Ribble Valley Borough Council  
Council Officers, Church Walk  
Clitheroe  
BB7 2RA

**Your ref:** 3/2021/0664  
**Our ref:** DC/21/2843  
**Date:** 27-JUL-21

**Location: Curtis House Chipping Road Longridge PR3 2NB.**  
**Proposal: Erection of workshop/storage unit.**

Job/Scheme Number		Drawing Number	
0621/93		Drawing No 03	
Scale	Date	Drawn	Checked
1 / 500	May 21	a.t.l-h.

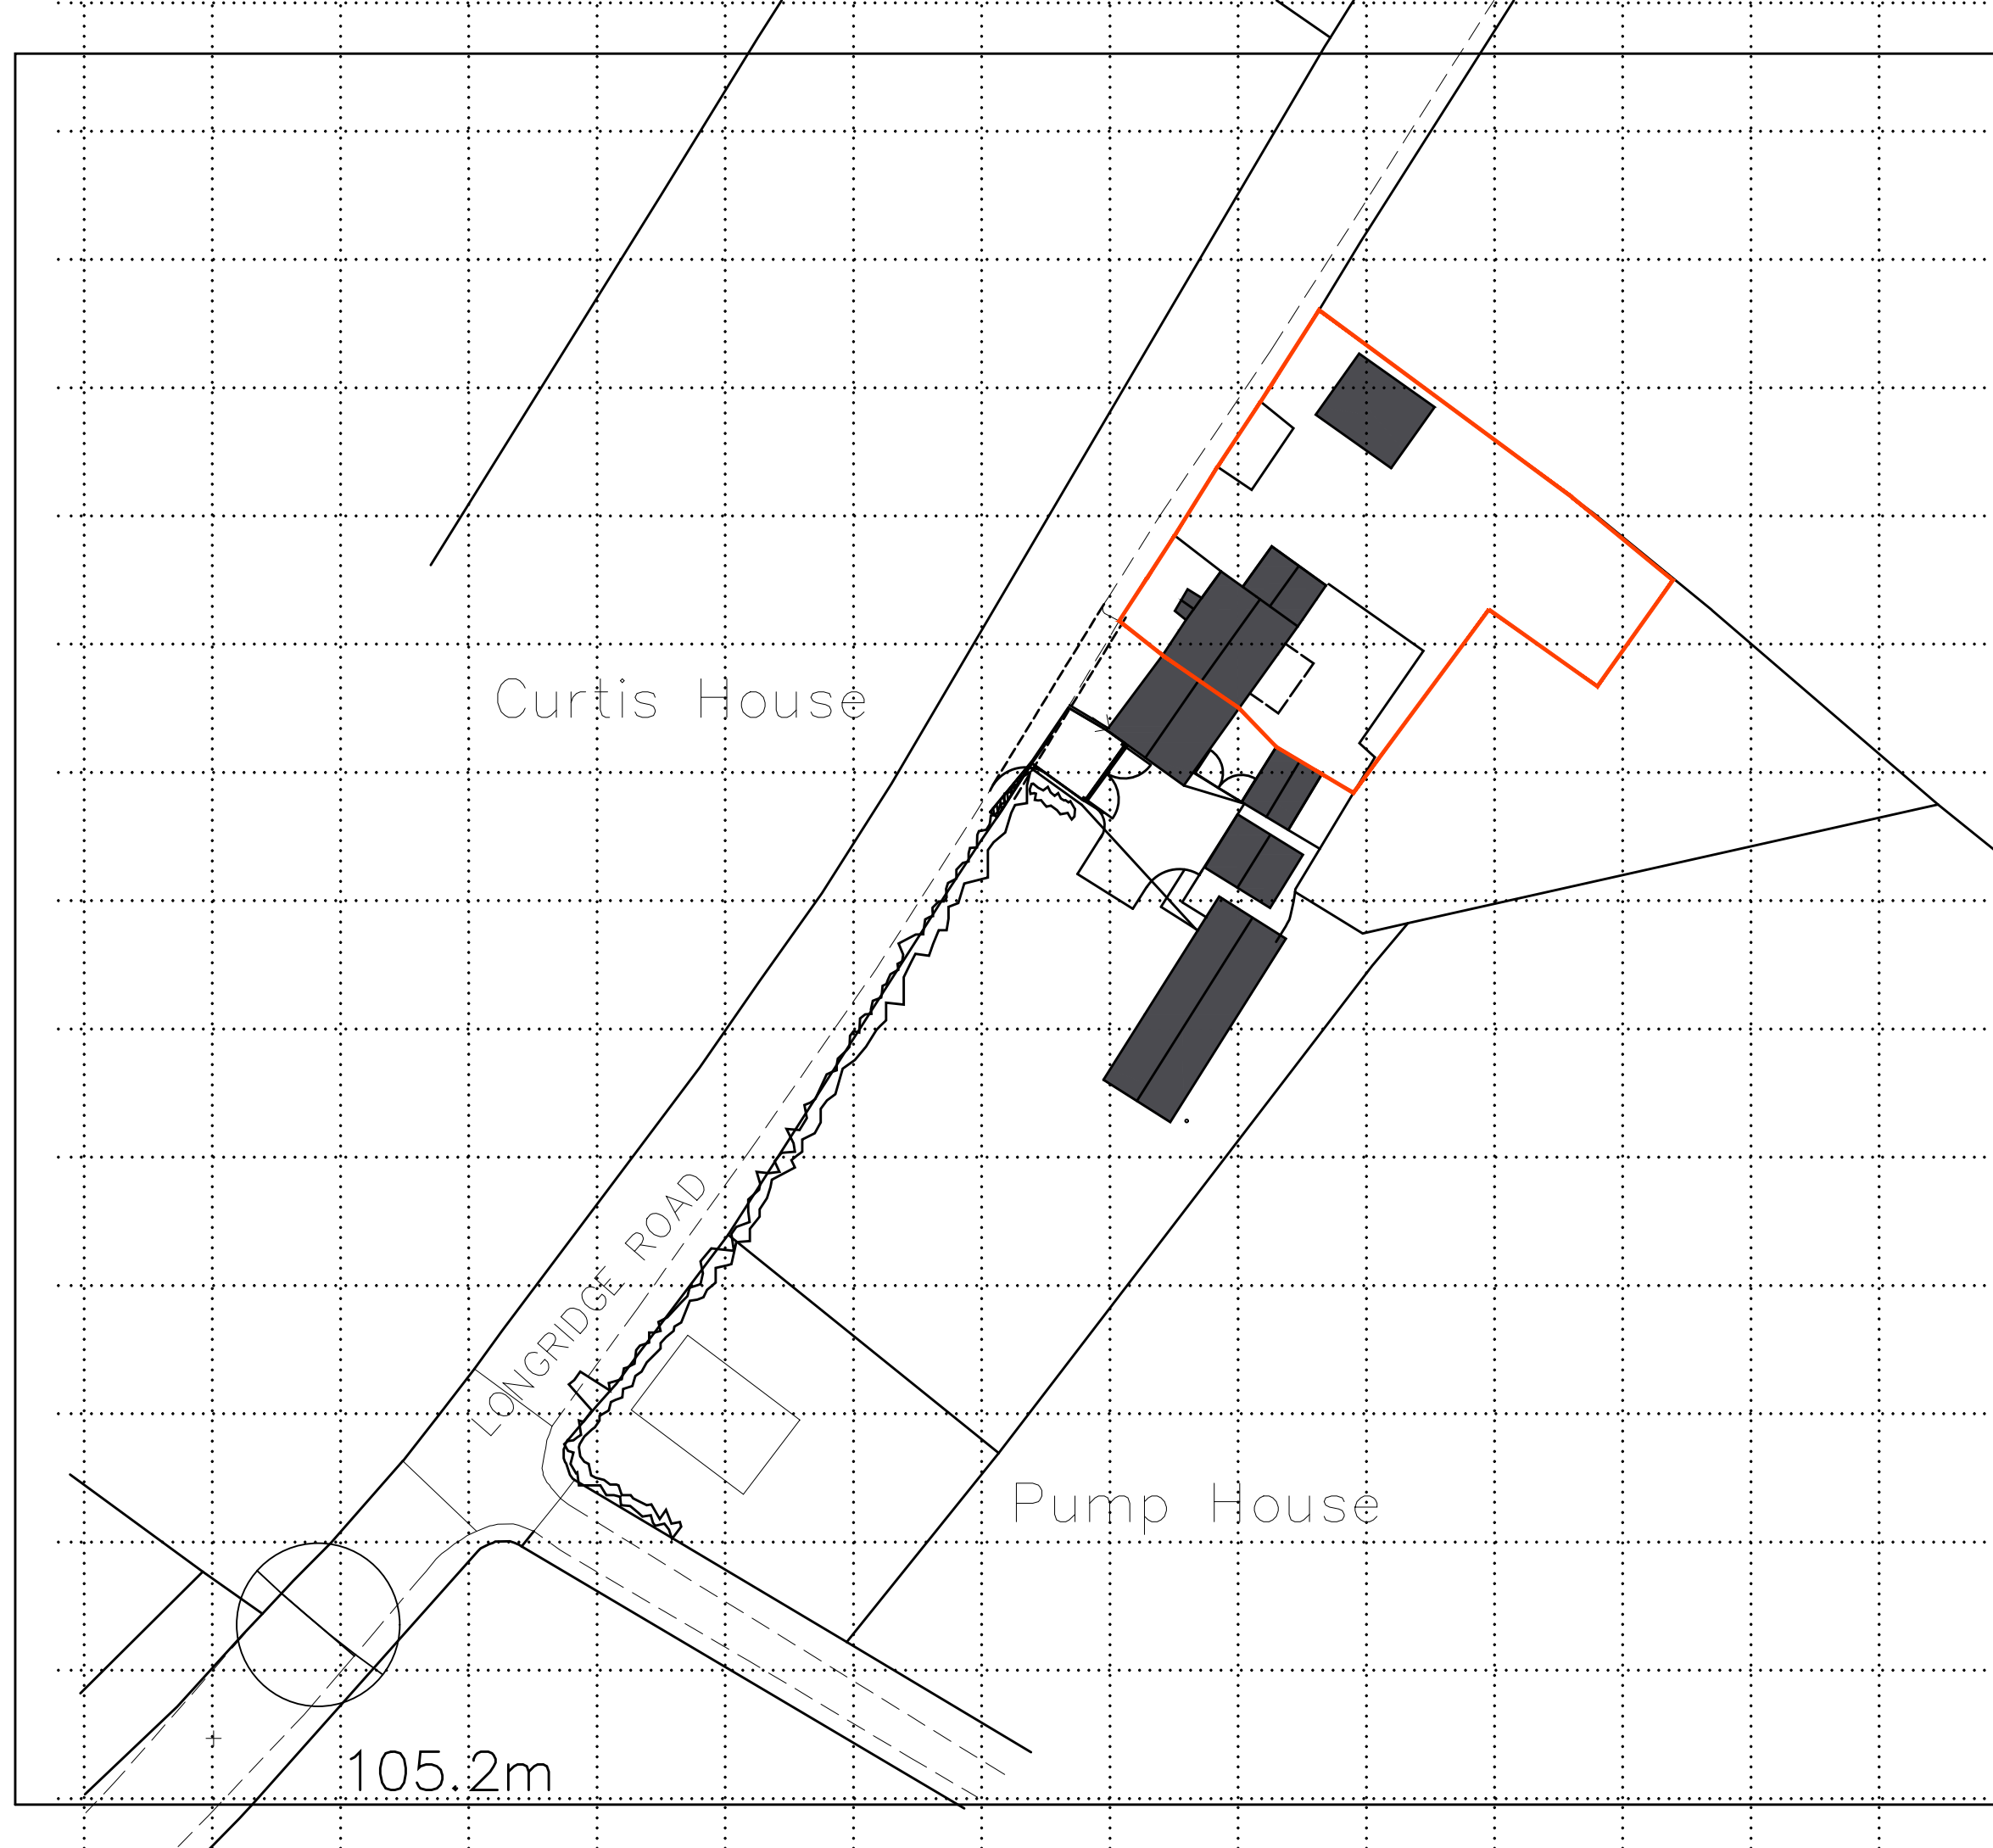
According to our records, the proposed development will be directly on top of our existing water main. This is not acceptable to United Utilities and therefore we must **OBJECT** to the proposal at this time.

**A water main crosses the site and the proposed building is planned directly over it.** As we need unrestricted access for operating and maintaining this water main and as such require an access strip as detailed in our 'Standard Conditions for Works Adjacent to Pipelines', a copy of which is enclosed, then a diversion would be necessary.

***No construction shall commence (including any earthworks) until details of the means of ensuring the water main that is laid within the site boundary is protected from damage as a result of the development have been submitted to and approved by the Local Planning Authority in writing.***
